Historic England

6 December 2022

**CAMPUS WEST, THE CAMPUS, WELWYN GARDEN CITY, HERTFORDSHIRE,
AL8 6BX**

Application No. 6/2022/2533/VAR

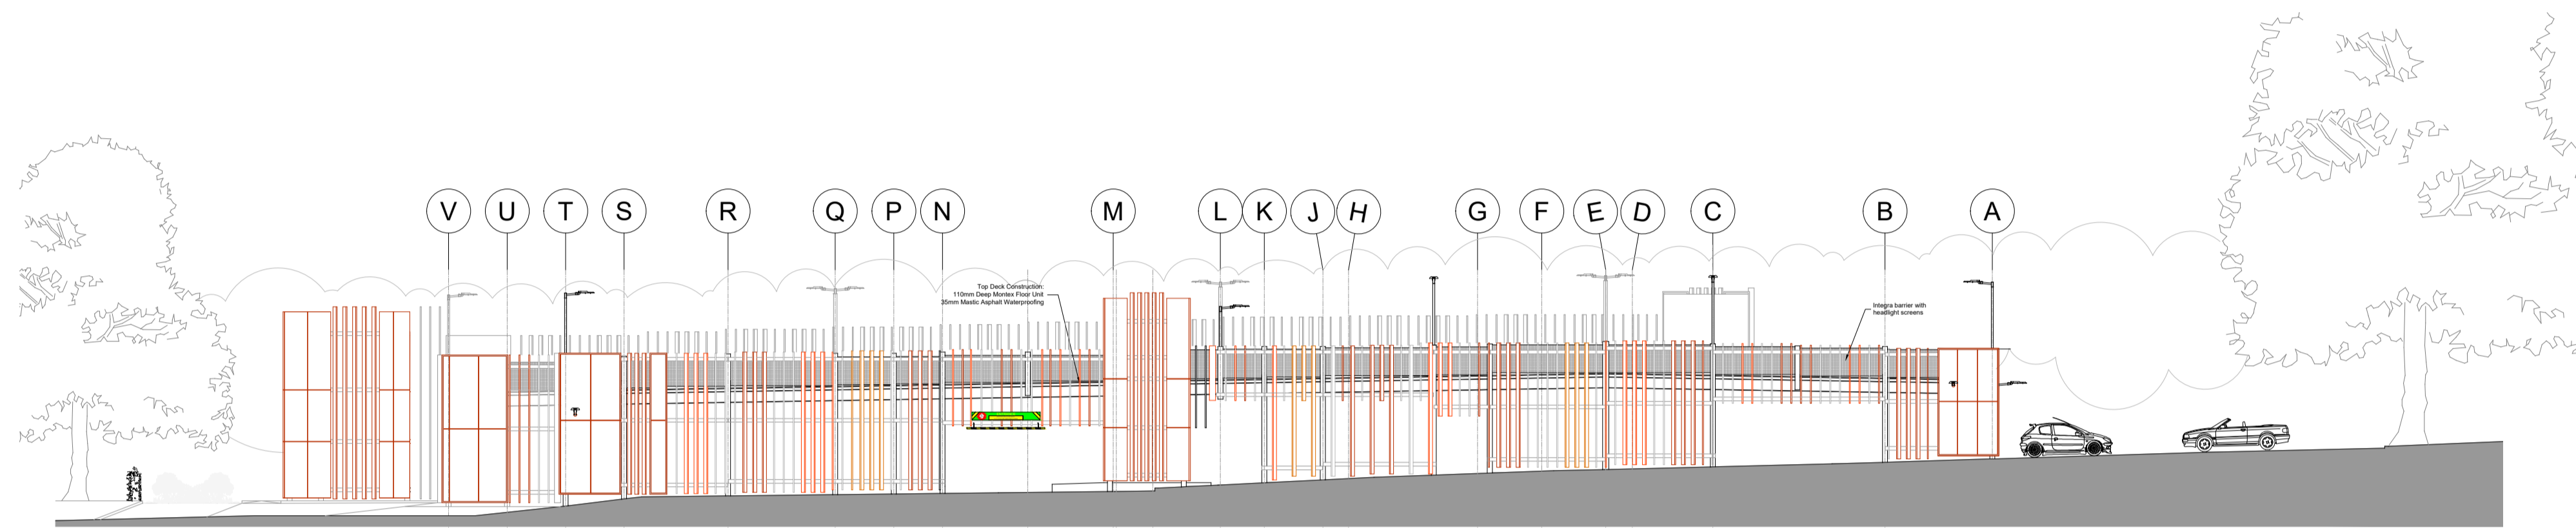
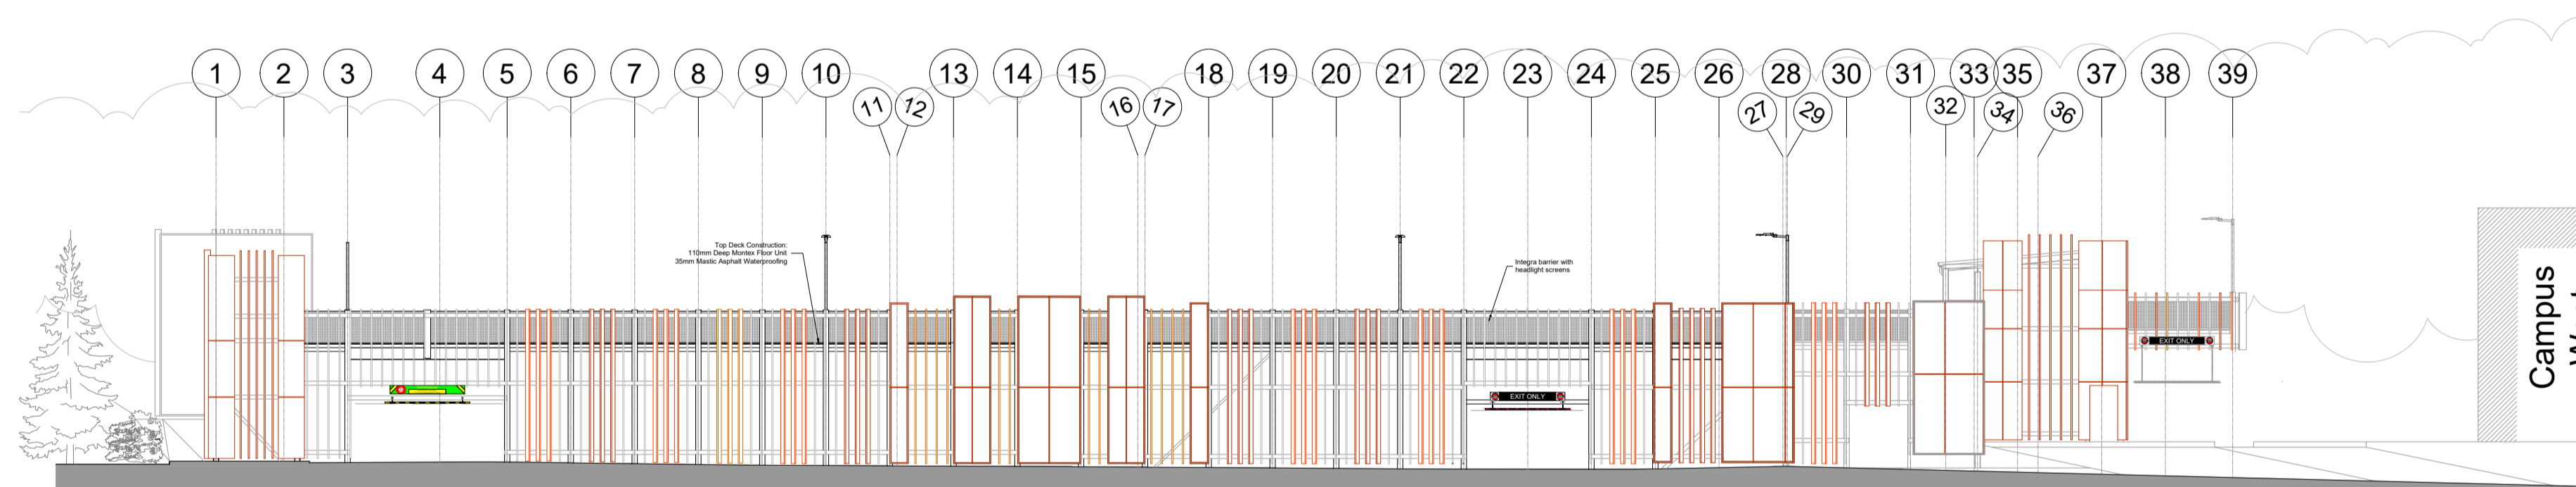
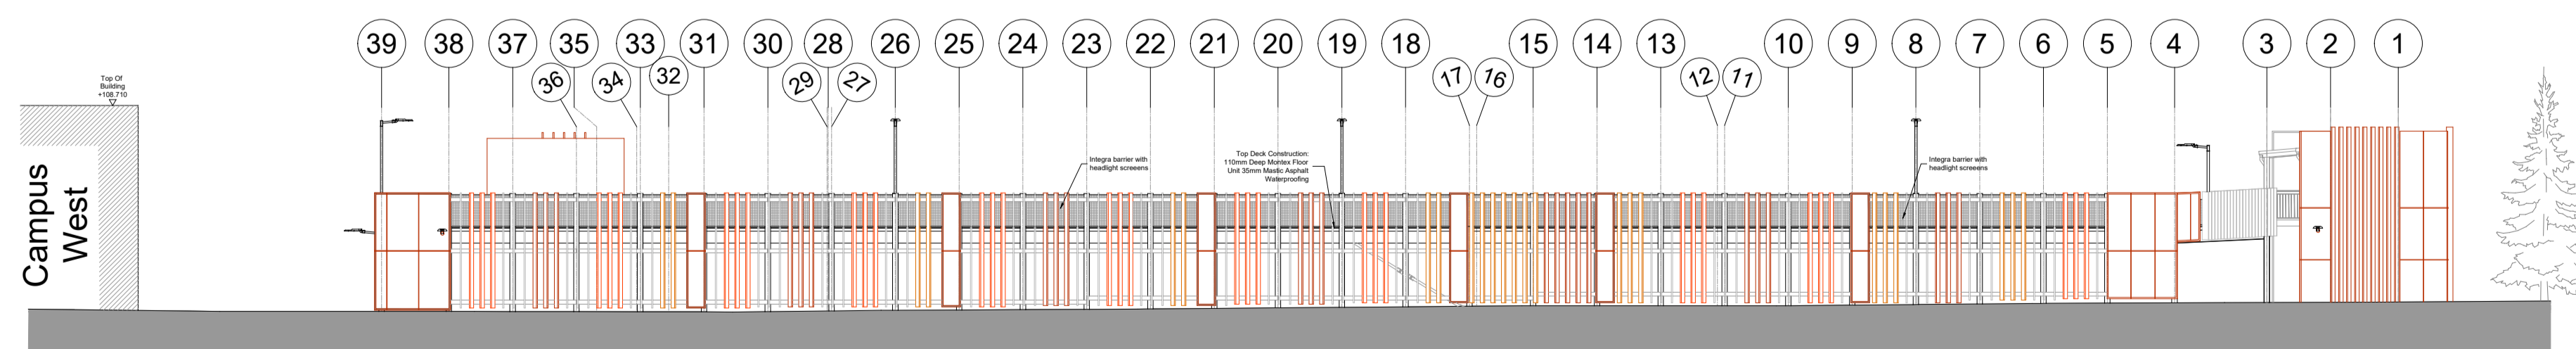
The letter accompanying the application states that the additional external lighting is proposed to provide additional lights to new pay meters situated within stairwell locations. It is difficult to tell in the proposed plan which of the external lights are additional from those approved in the original application but, it appears that the external lights marked as blue on the submitted plan, in 3 instances, do not correspond with either stairwells or parking meters. If new lights are required, are others able to be removed?

At present, we consider that justification should be provided for the additional illumination due to the additional impact of the lighting upon the character of the Conservation Area. It therefore would not accord with the information requirements of paragraph 194 of the NPPF.
